Reference No:	2025/62/92280/W
Site Address:	23, Kew Hill, Lindley Moor, Huddersfield, HD3 3SY
Description:	Erection of single storey rear extension with balcony
Recommending Officer:	Joshua Merriman

DECISION – Conditional Full Permission

Officer Report – 2025/92280

Elevations & plans (proposed)

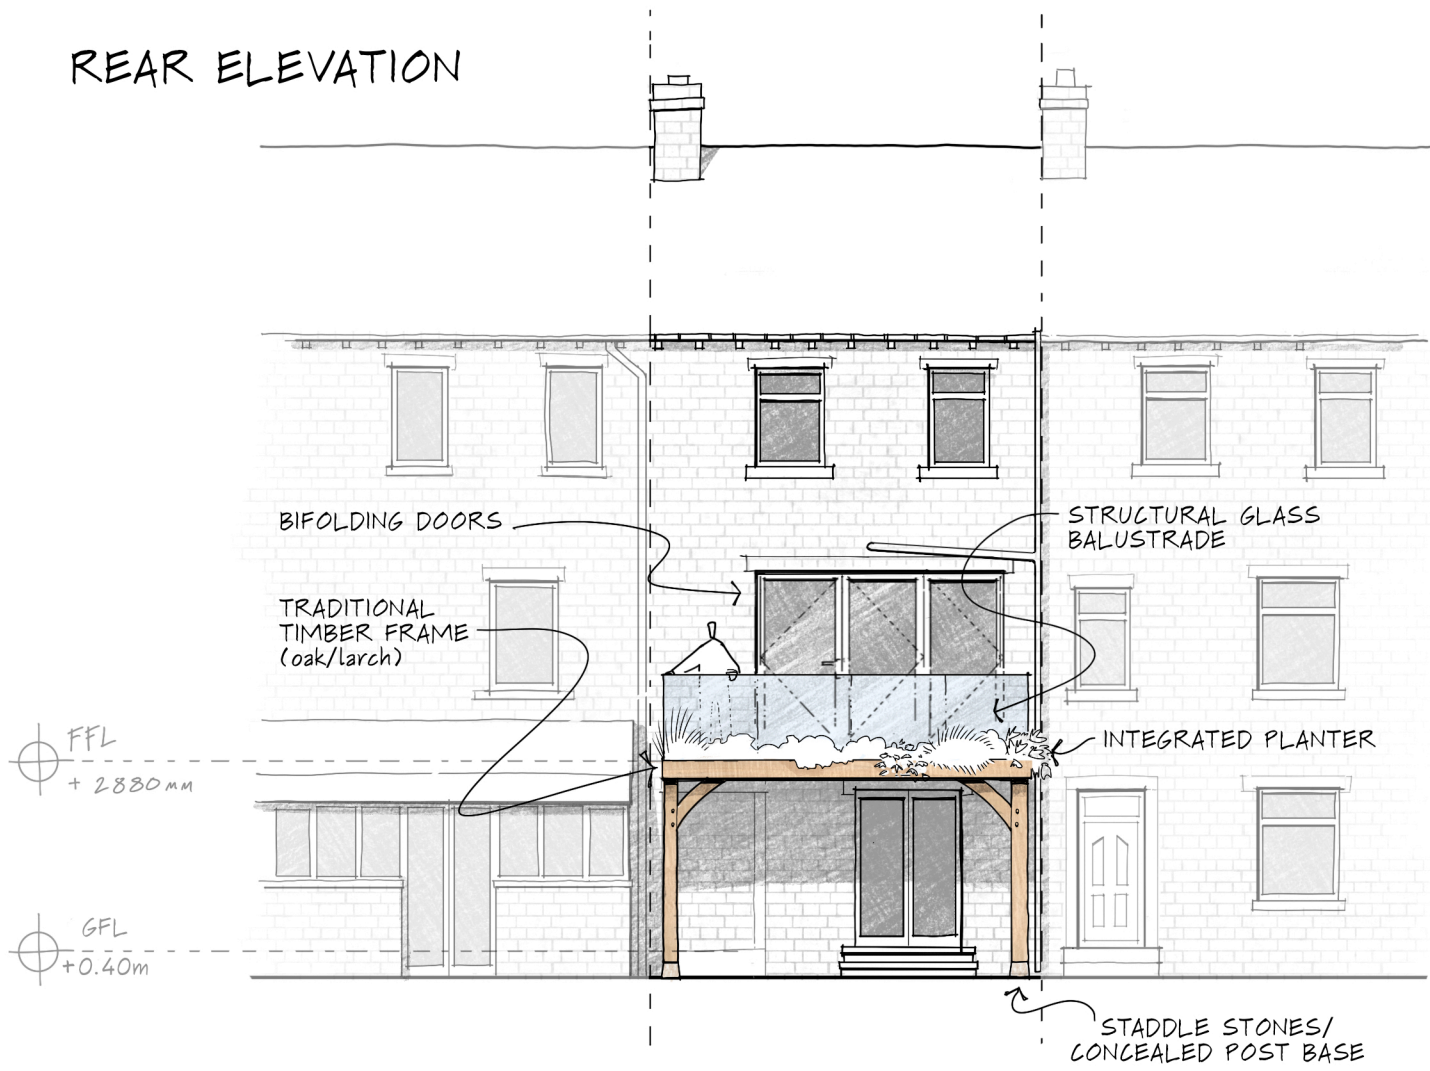
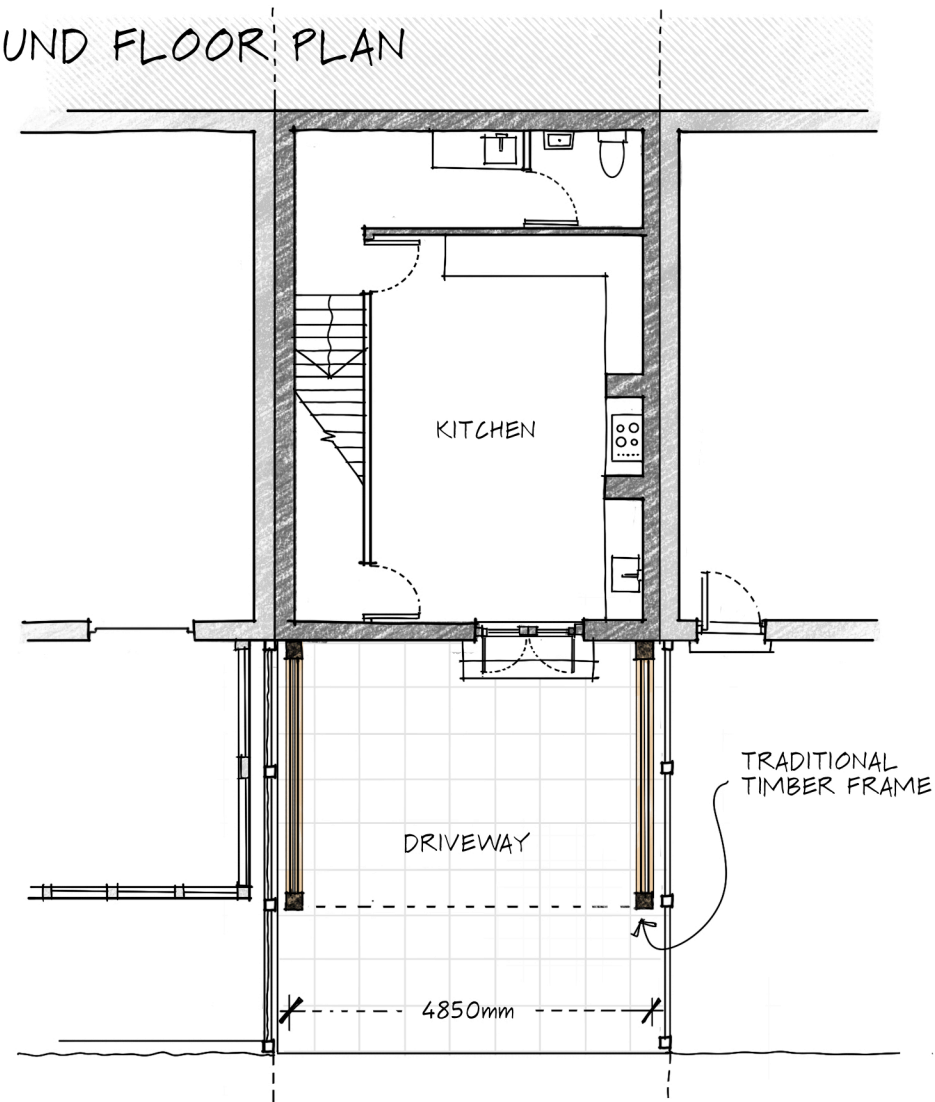
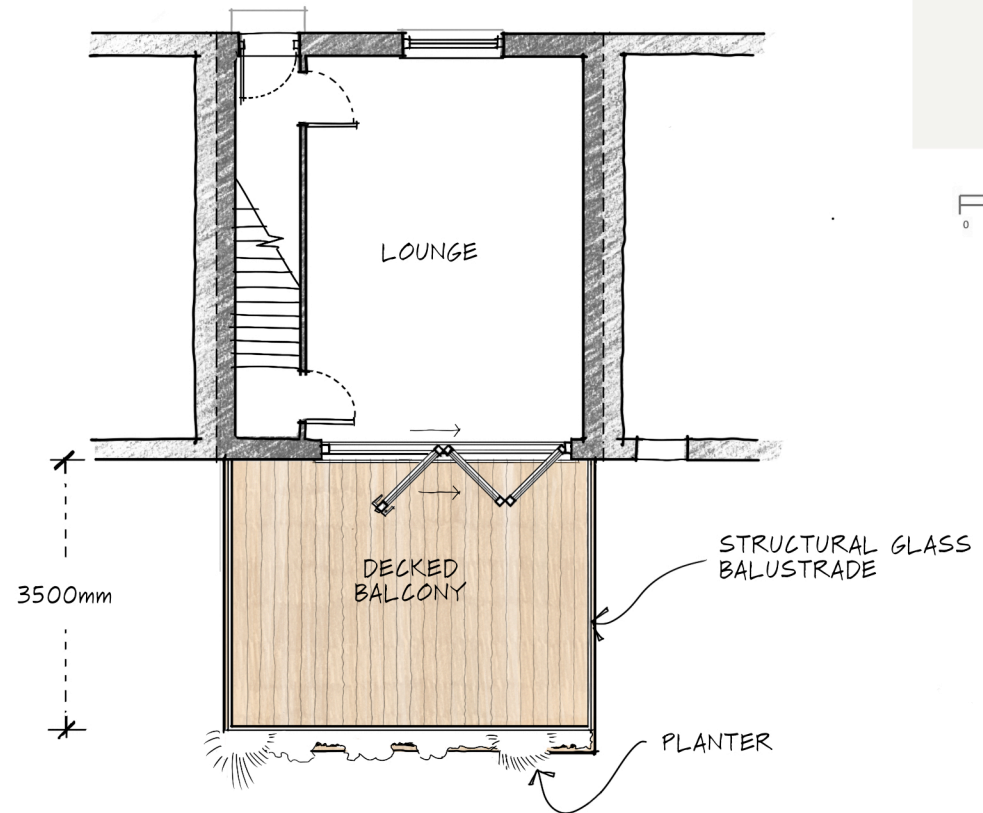
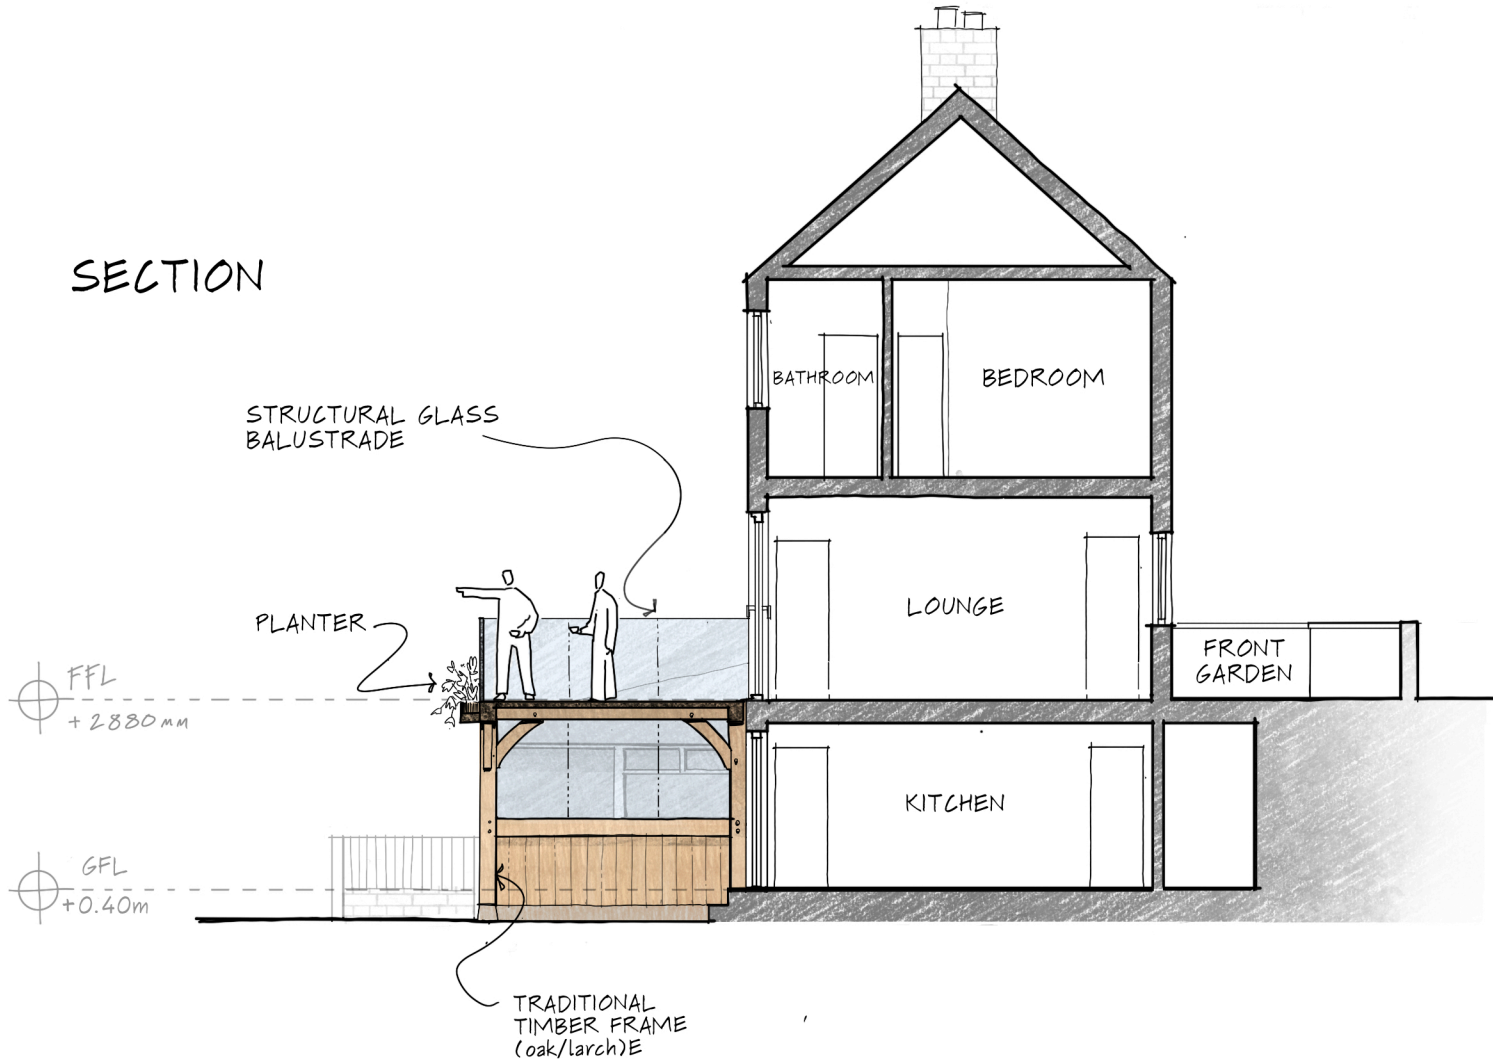
As for the proposed balcony, it is considered that there would be no significant extra overlooking facilitated into neighbouring amenity space compared to what is currently available via the rear windows of the application property, however, it is noted that the residents may be able to look into the rear windows of adjoining properties when standing on the proposed balcony. As a result, a condition has also been added stipulating the erection of privacy screens to each side of the balcony to prevent significant impacts with regard to overlooking and privacy. Finally, the balcony is considered to be sited away from a location that is sensitive to additional noise levels and disruption.

3. Notwithstanding the plans submitted, the balcony shall not be brought into use until obscurely glazed screens (to a minimum privacy level of Grade 4 or equivalent) to a height of 1.8m high have been constructed

to the South West and North East elevations of the balcony. The obscure glazed screen shall thereafter be retained.
